Y/110/21/L

Stakers Farm North End Road Yapton BN18 0DU

Listed building consent to upgrade the existing access with new turning area and addition of a garage (This application may affect the Character and Appearance of the Main Road Yapton Conservation Area)

BLOCK PLAN
1:500

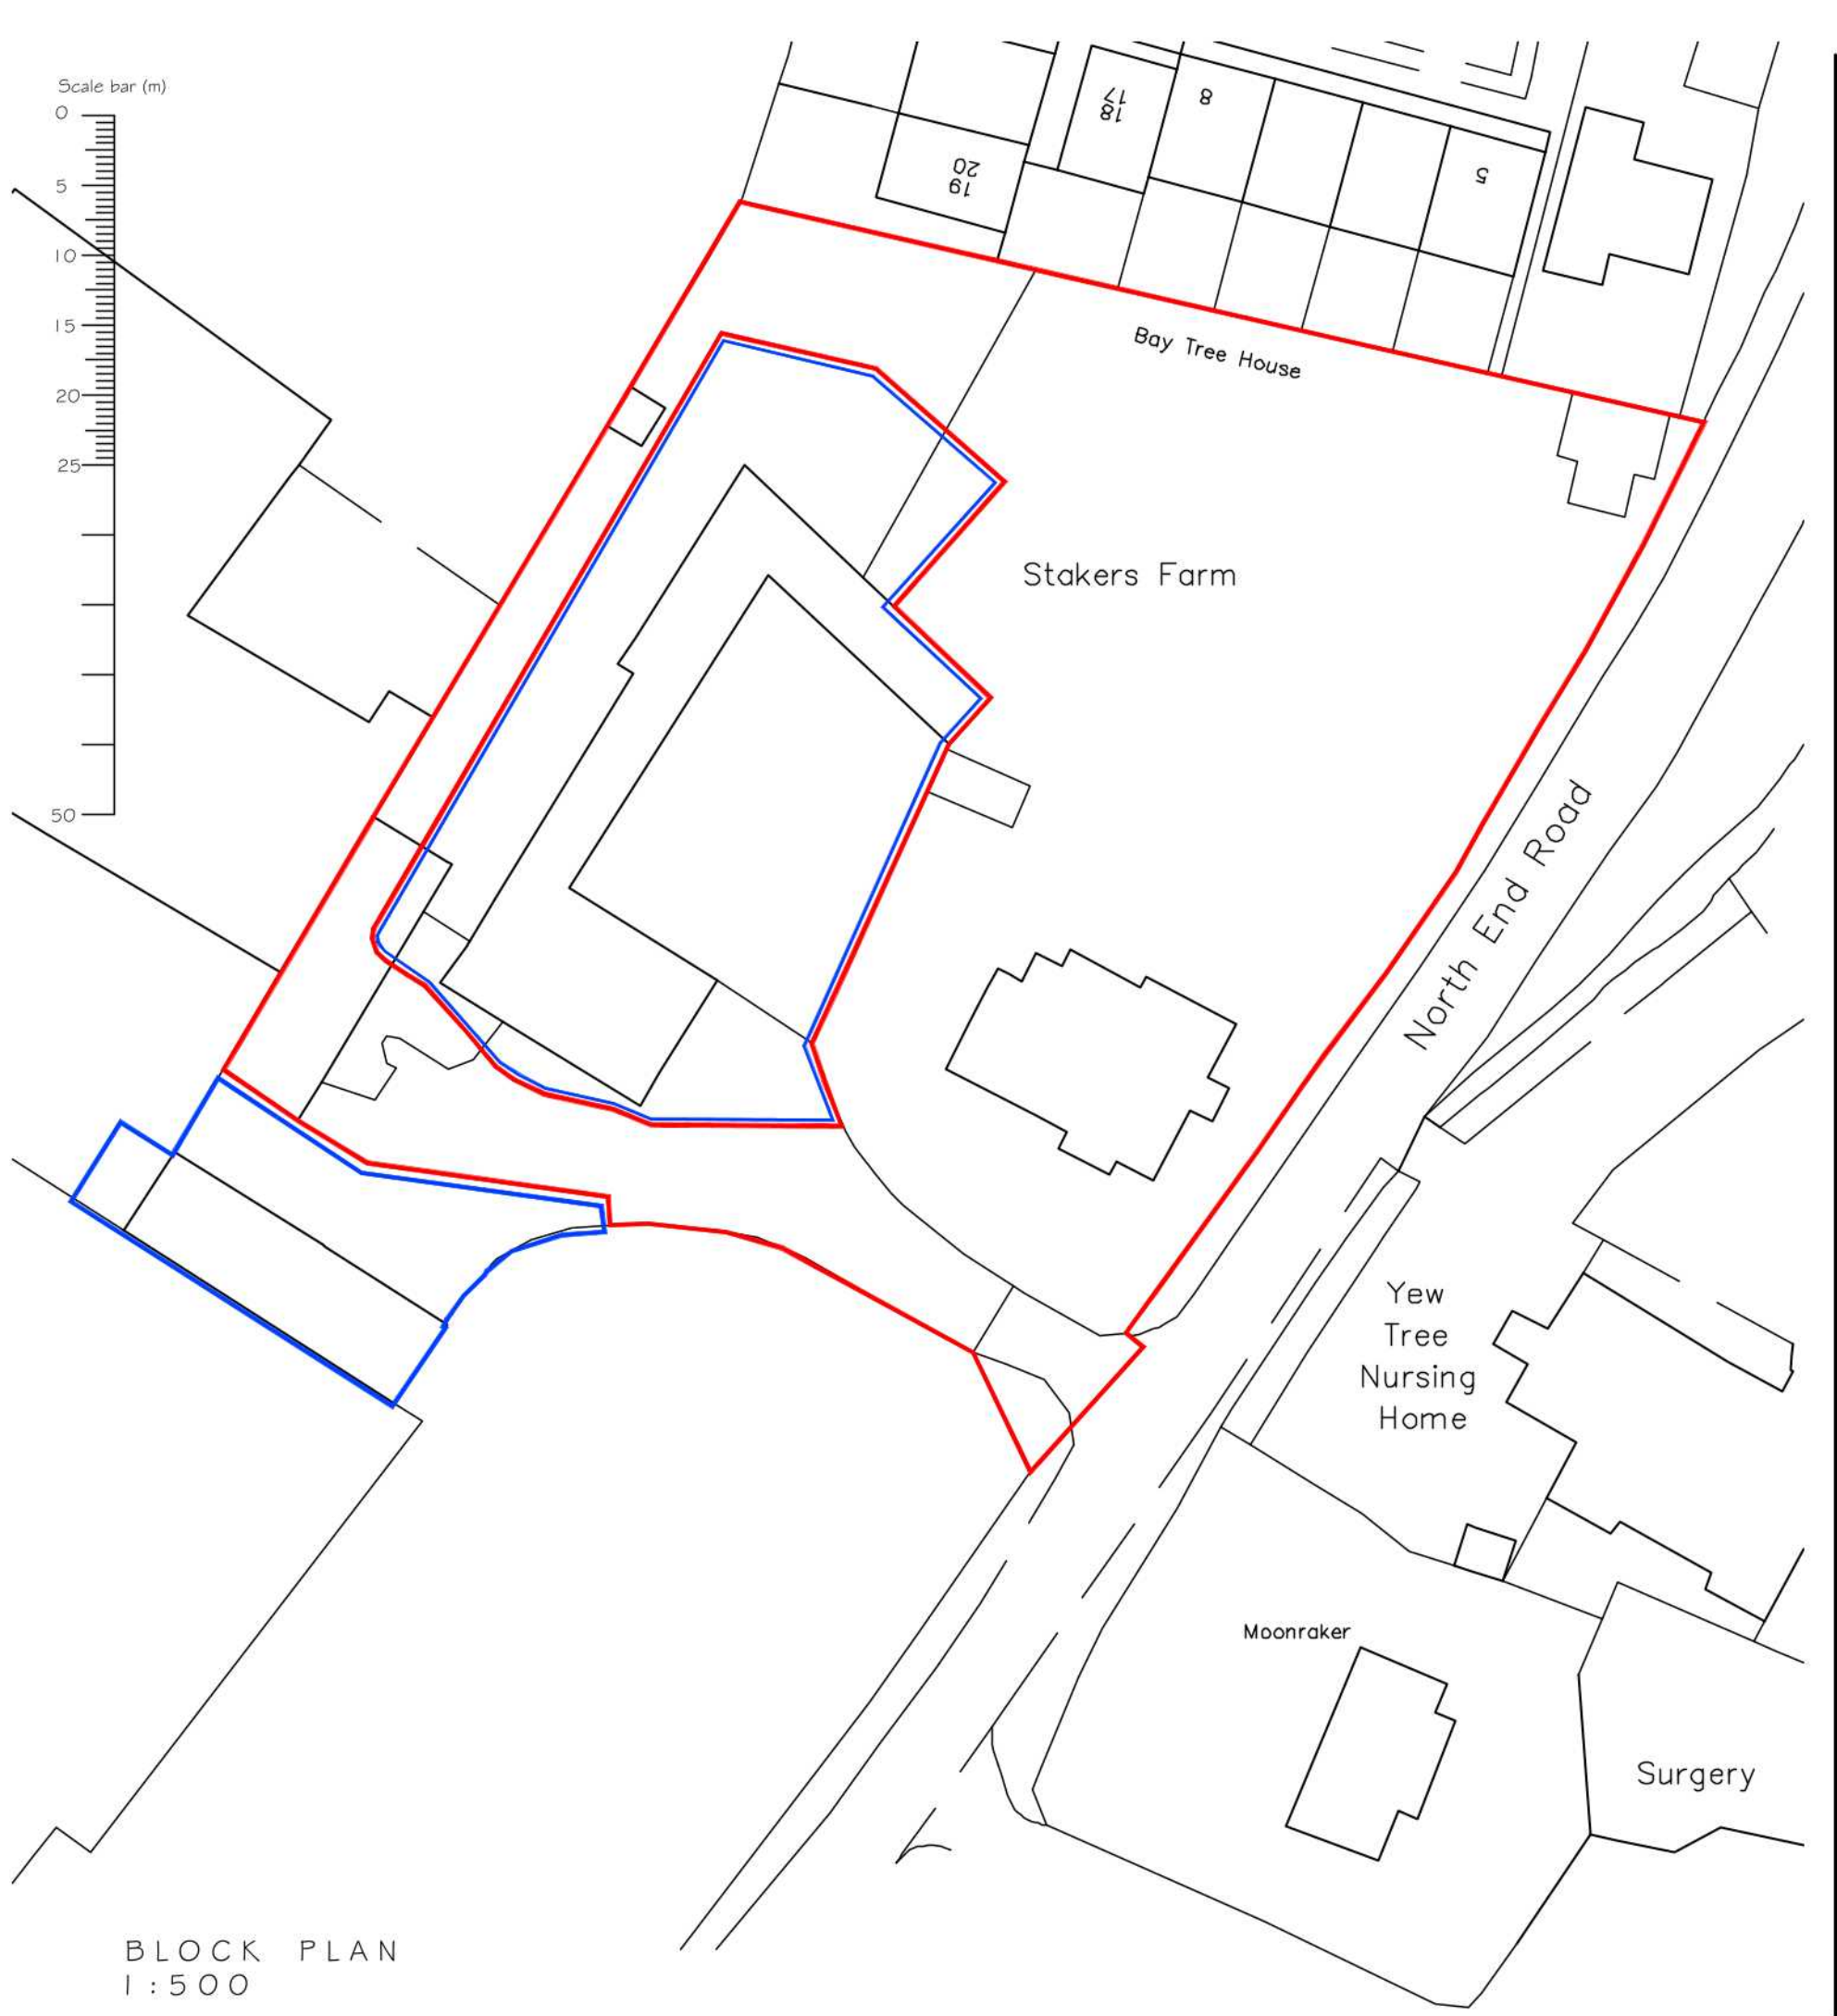
From looking at the site plan provided as part of this application, it would appear that the red site boundary would cover an area of hardstanding which would separate proposed units 2 and 3 of the barn conversion scheme. This area is also covered in two separate applications (see Y/107/21/PL and Y/108/21/L). A significant area would be paved in order to provide access to the parking courtyard as well as to the new cobbled driveway and vehicle turning area.

The use of brick paviours is of some concern, as this could introduce a sub-urban character into what should be a more rural one. It is not clear why such a material was chosen, when something more in keeping would be more appropriate. If it could be proven that the paviors selected would reflect the more rural location and age / type of buildings in the development, there is a chance that they could be acceptable. Therefore, if you are minded to approve the application, I would recommend that details of the paviors are provided. This could be achieved by way of condition.

DRAWING TITLE
PROPOSED GARAGING / STORE FOR
MAIN HOUSE AND HOUSING FOR
SALVAGED STALL DIVIDERS

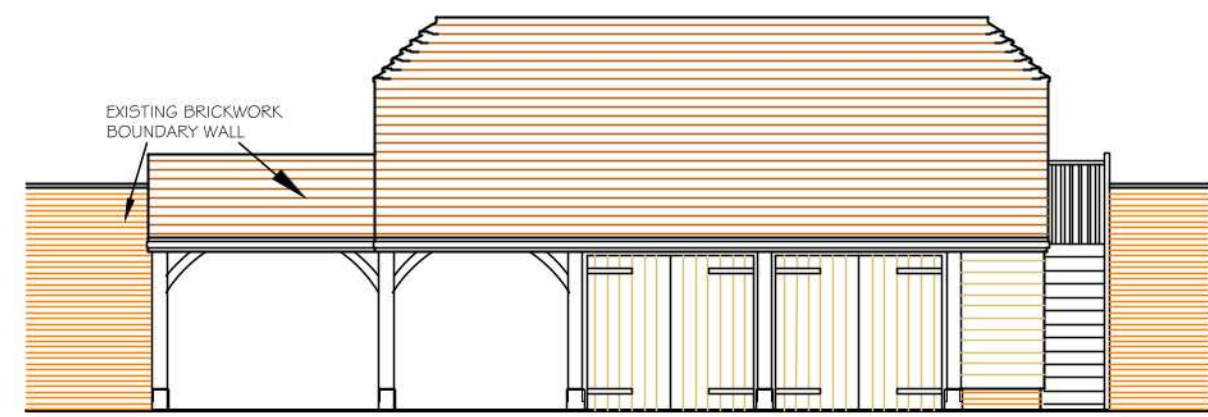
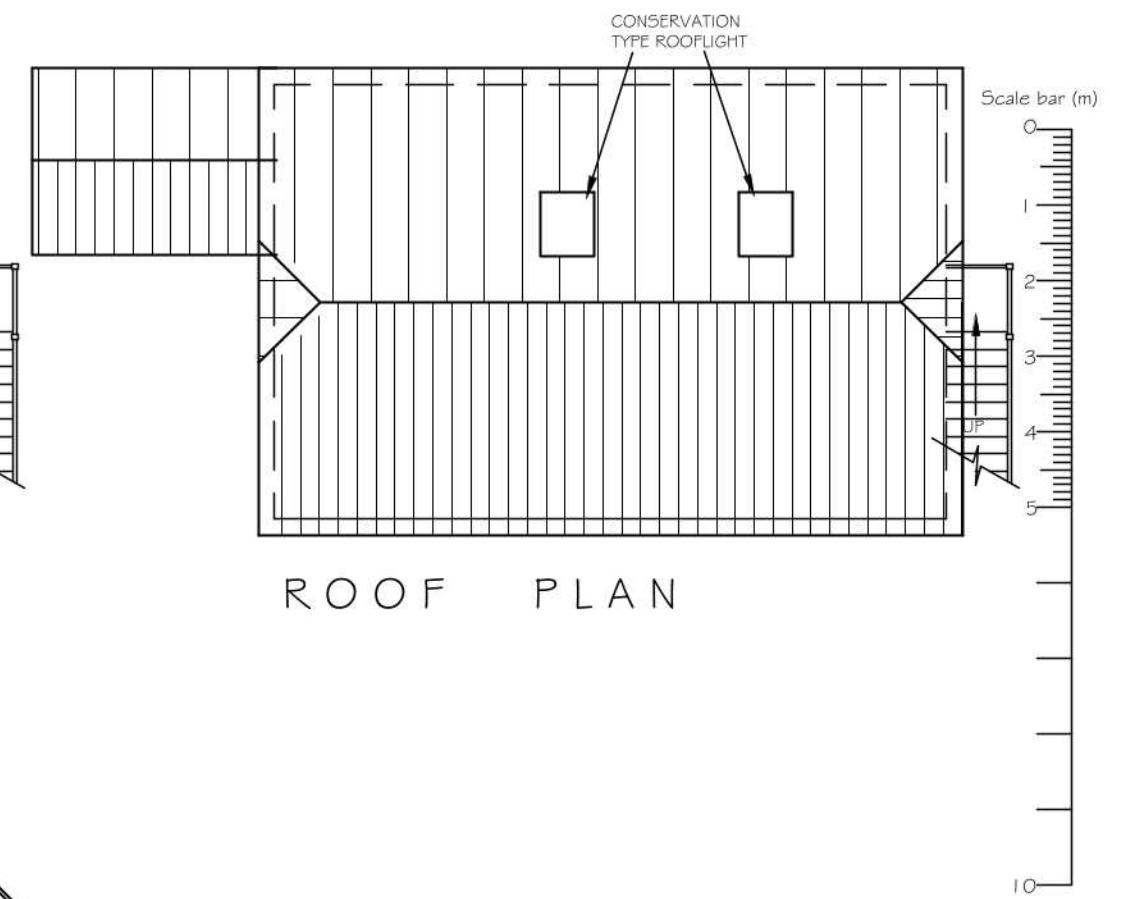
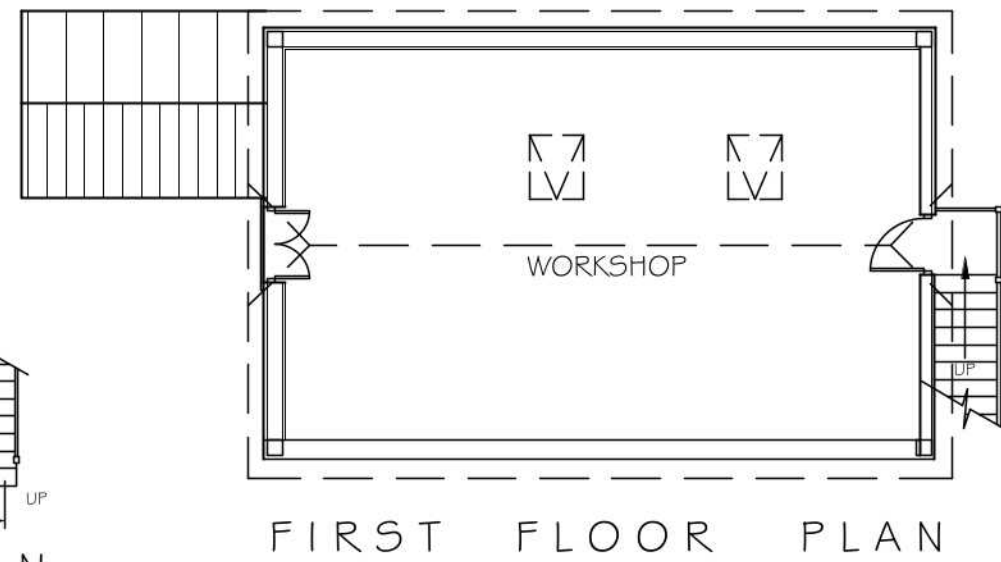
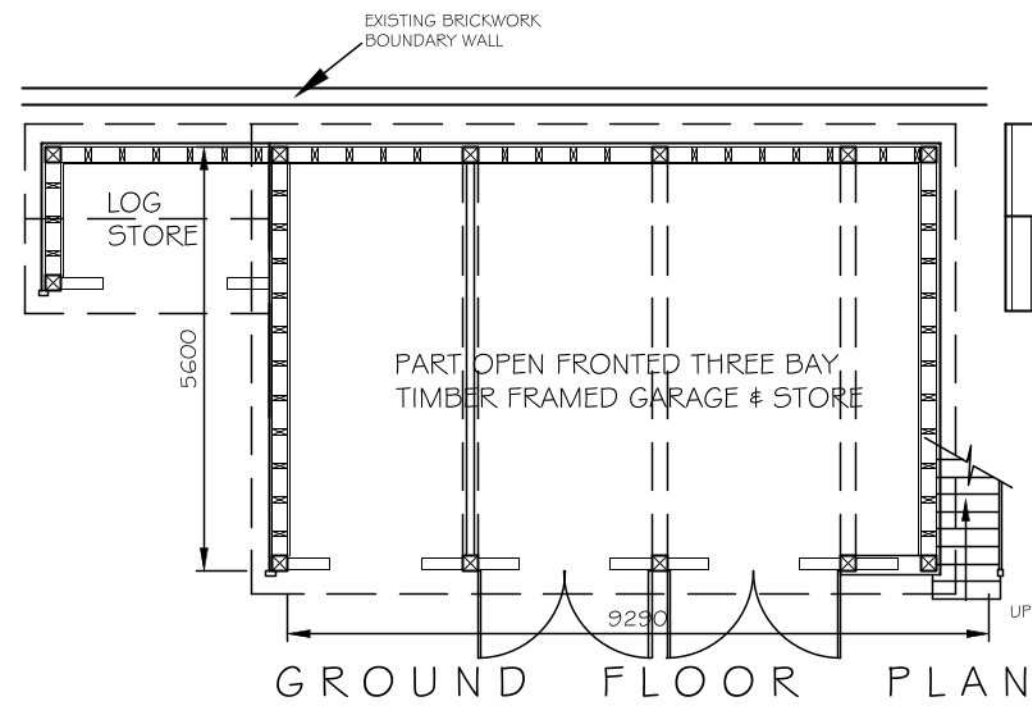
The proposed garage building is of a standard timber framed barn with log store. It is of timber construction with a tiled roof and two conservation rooflights. The design and location appear to be acceptable and would not cause harm to the setting of the listed and curtilage listed buildings. The success will depend upon the materials used and it would help to understand what the windows and doors will look like, what materials will be used and how they will be treated i.e. stain or painted etc. These details can be supplied by way of condition if you are minded to approve the application.
